DRB Application No.: <u>02-<del>A</del>01678 (SBP)</u>	Project # <u>1002327</u>
Project Name: <u>ALAMEDA BUSINESS PARK</u>	EPC Application No.:
Agent: <u>Rick Bennett Architects</u>	Phone No.:

## DEVELOPMENT REVIEW BOARD TRANSPORTATION DEVELOPMENT Standard Comment Sheet

DRB-1002327

DEVELOPMENT REVIEW BOARD--SPEED MEMO

1 WEST ELEVATION  
A2 1/8"=1'-0"

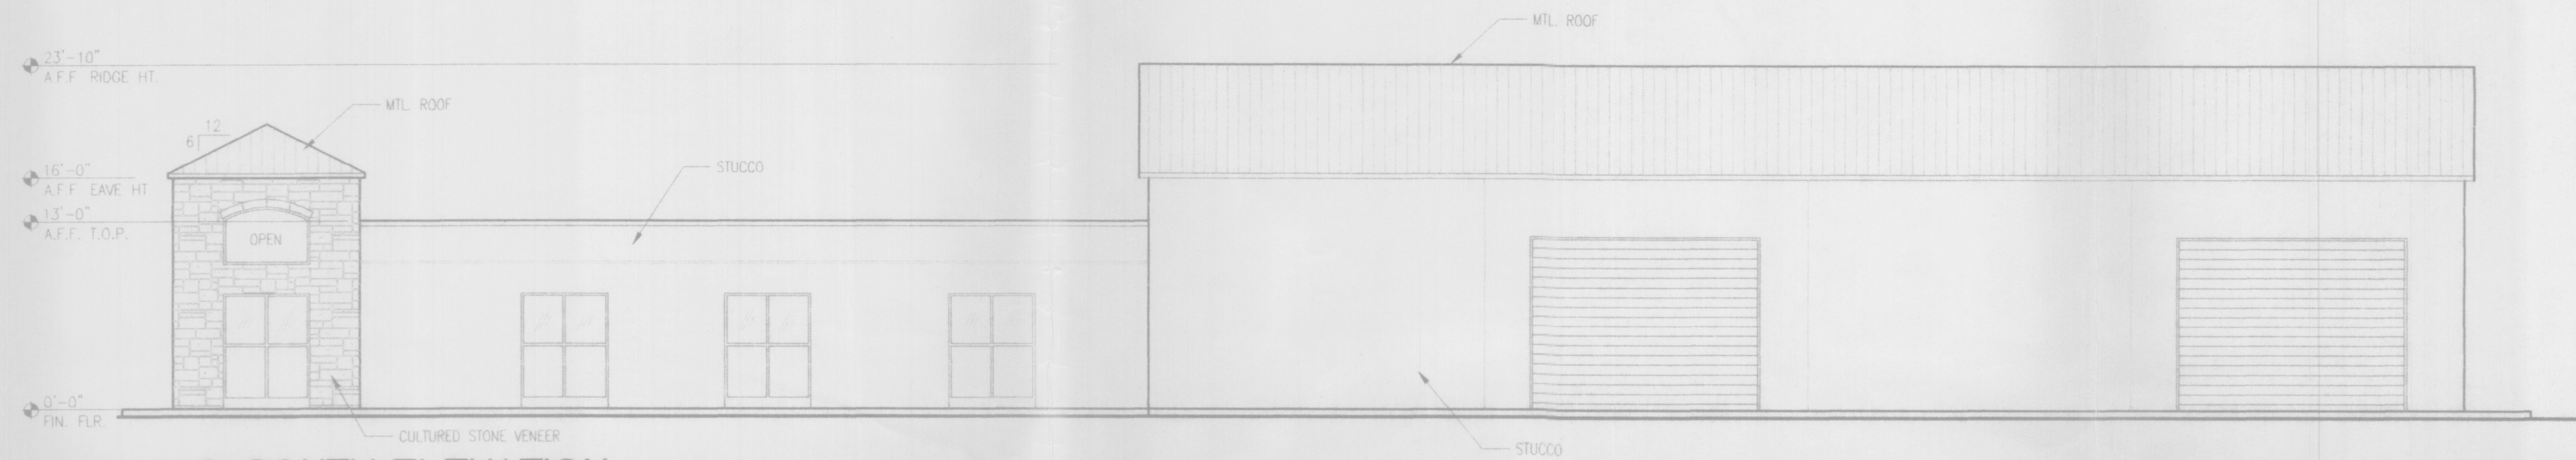
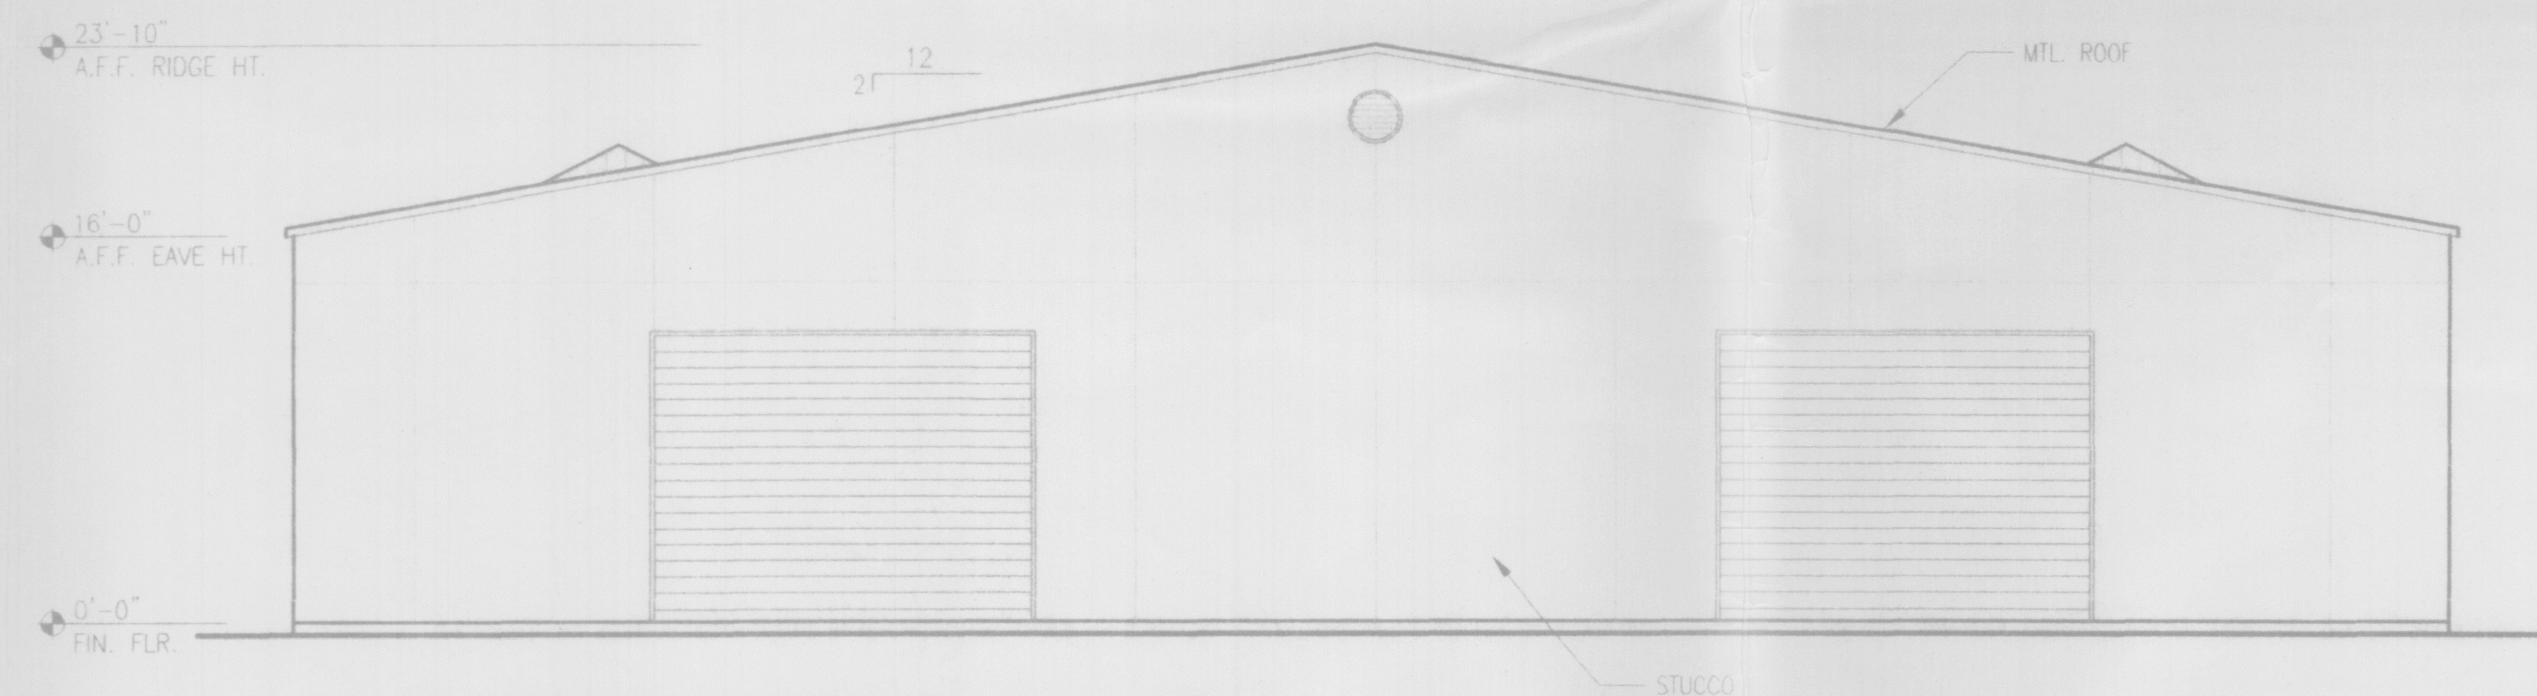
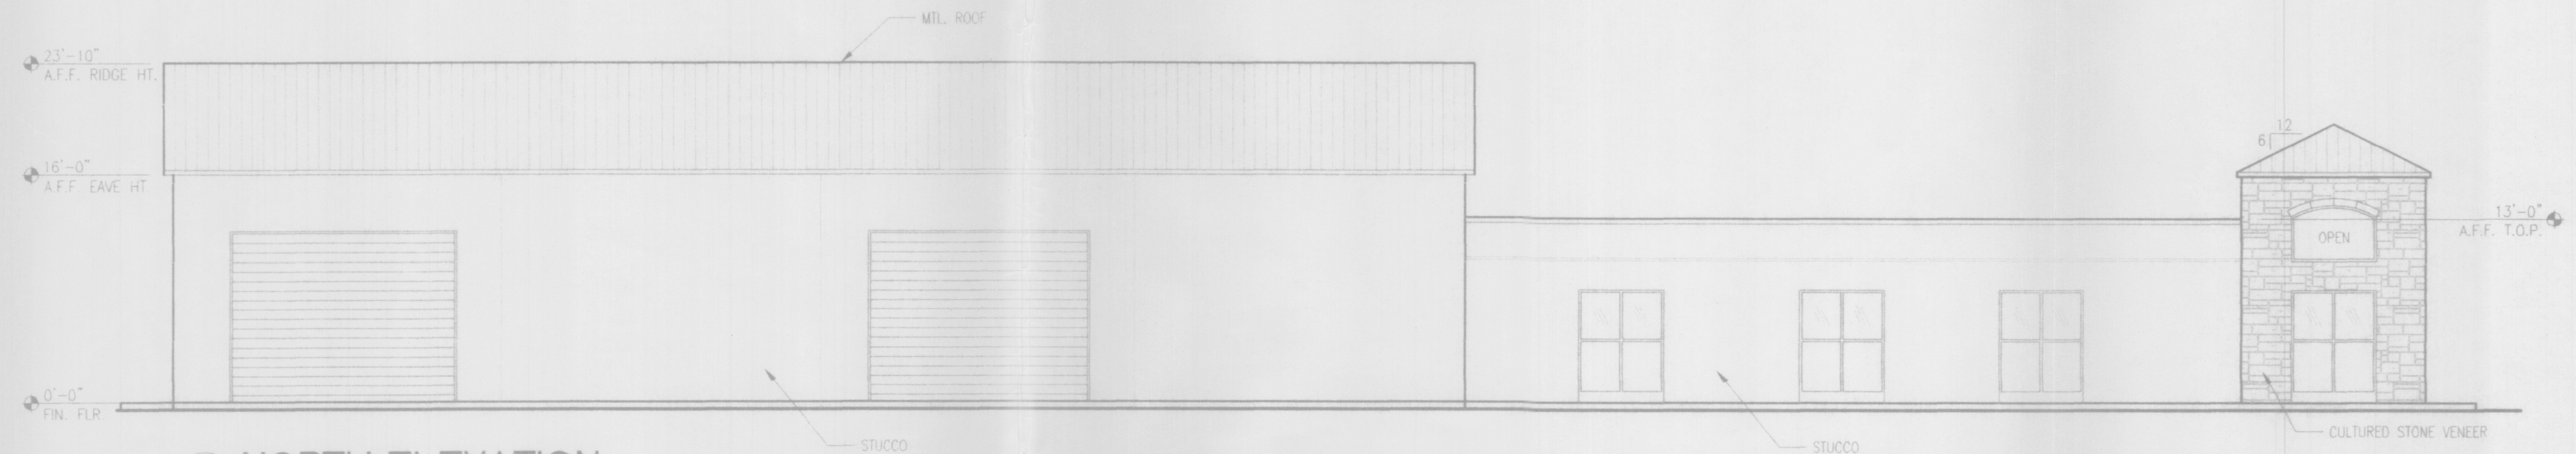
3. Exterior Elevations Sheet

This sheet is missing the bar scale.
